Consultation Response from KC, Highways Development Management		
2020/92657 King James School, St Helen's Gate, Almondbury, Huddersfield, HD4 6SG		
Erection of 10 classroom teaching block and formation of car parking area with associated engineering and landscape works (within a Conservation Area)		
Date Responded:06/10/2020	Responding Officer: Mark Berry	Responding Ref: 11-5-5

0711 Site Plan
1 : 200

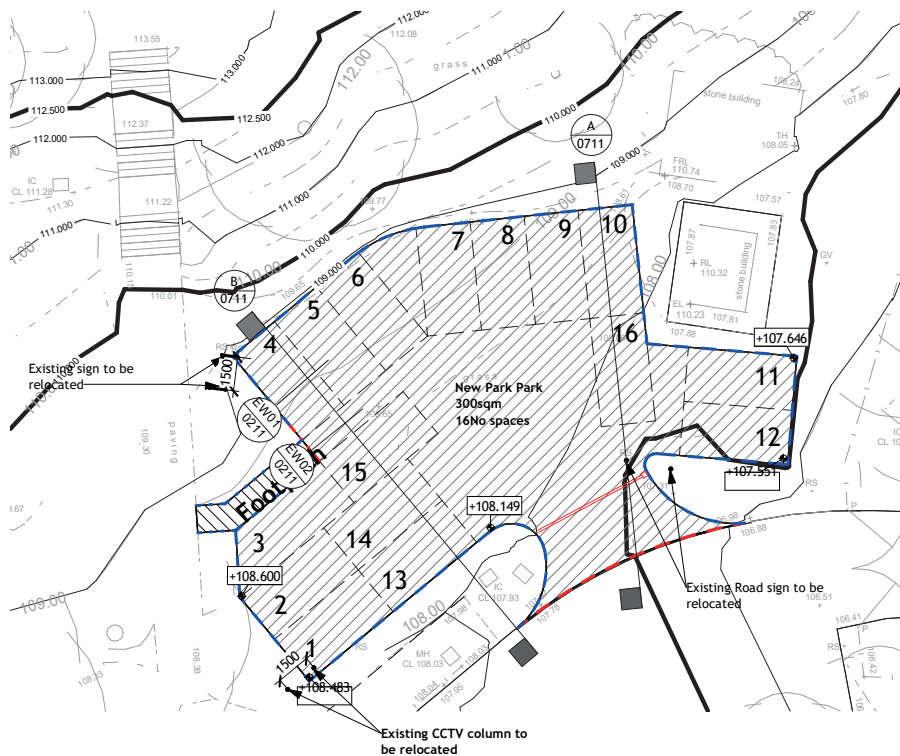
Additional off-street parking for 16 vehicles is shown to be provided.

Changes in PAA following the closure of Almondbury Community School

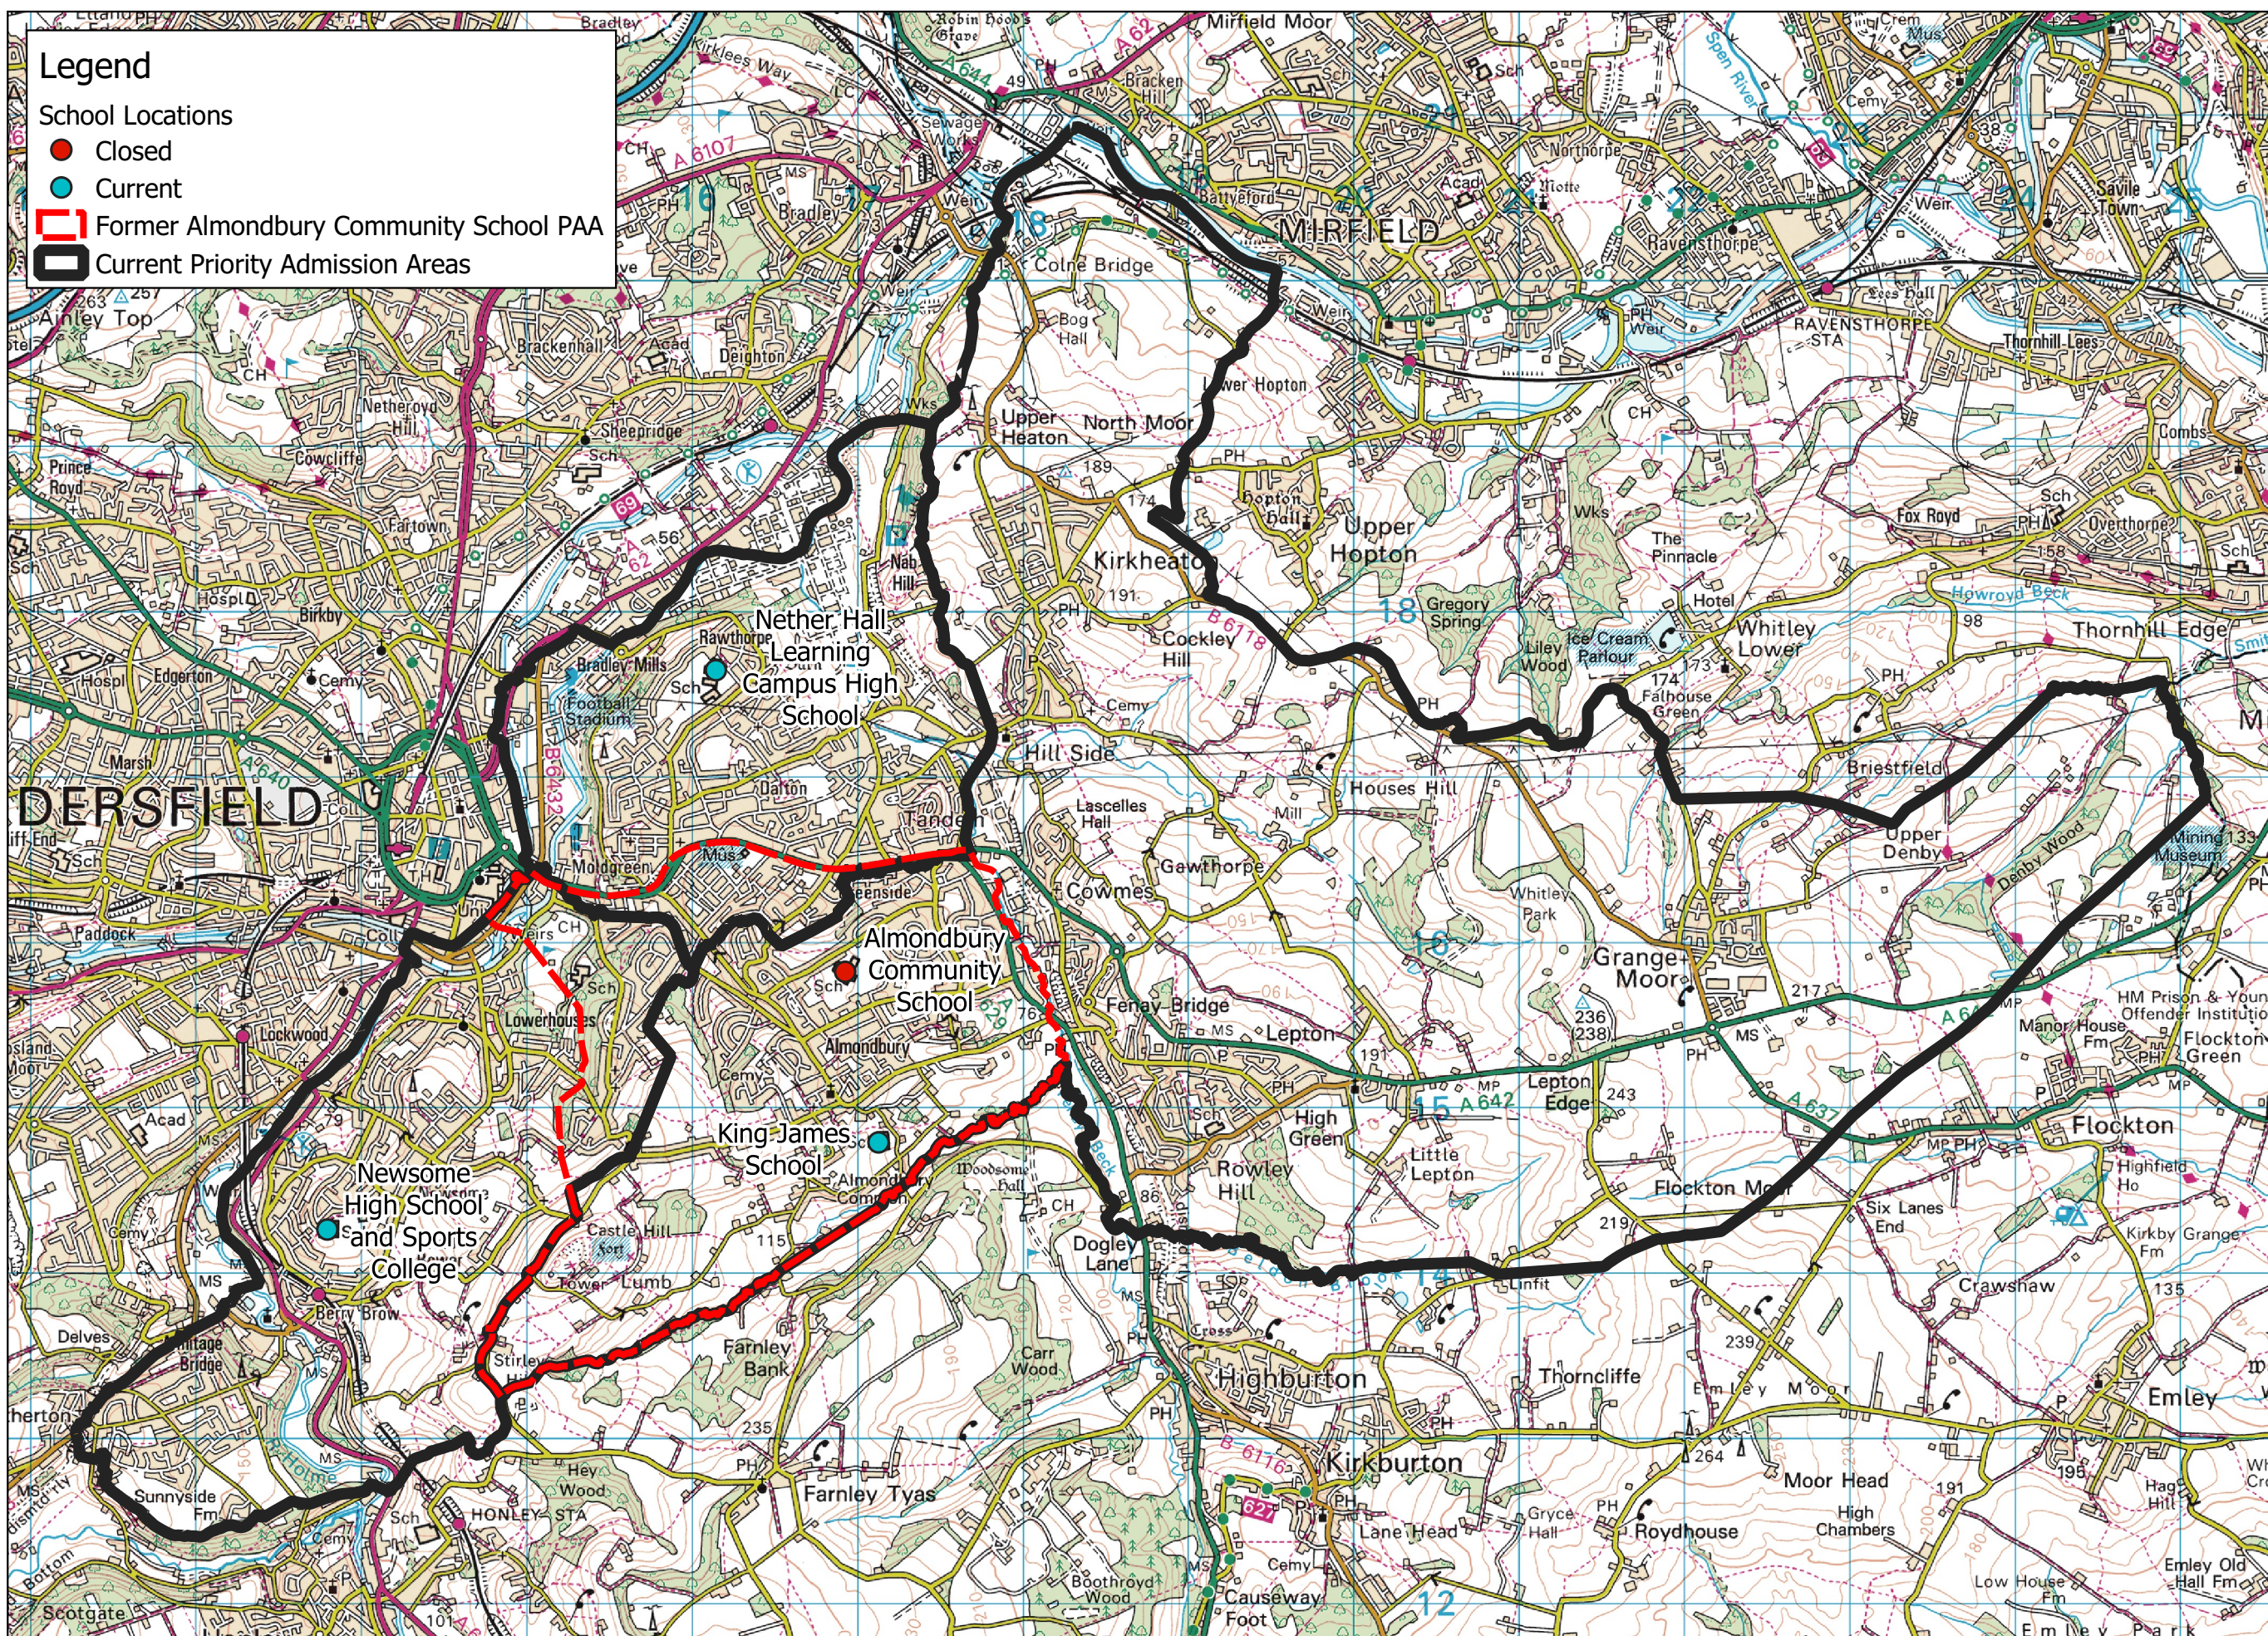
The TS confirms that as of September 2020, the school Priority Admissions Area (PPA) is to be extended to include the school site and the surrounding area of Almondbury. The revised PAA is illustrated on the plan attached at Appendix BGH4 of the TS.

This additional catchment area includes a large residential area to the north of Westgate and Fenay Lane which represents most of the area of the village of Almondbury. The most direct route to school from this area is likely to be via Fenay Lane and St Helens Gate.

The TS confirms that between 22 and 32 percent of existing pupils currently walk to or from the school, given the proximity of this additional area to the school this percentage is likely to be much higher.

Highways Development Management would therefore consider that the cost of the provision of this proposed crossing should be met by the developer of this site.
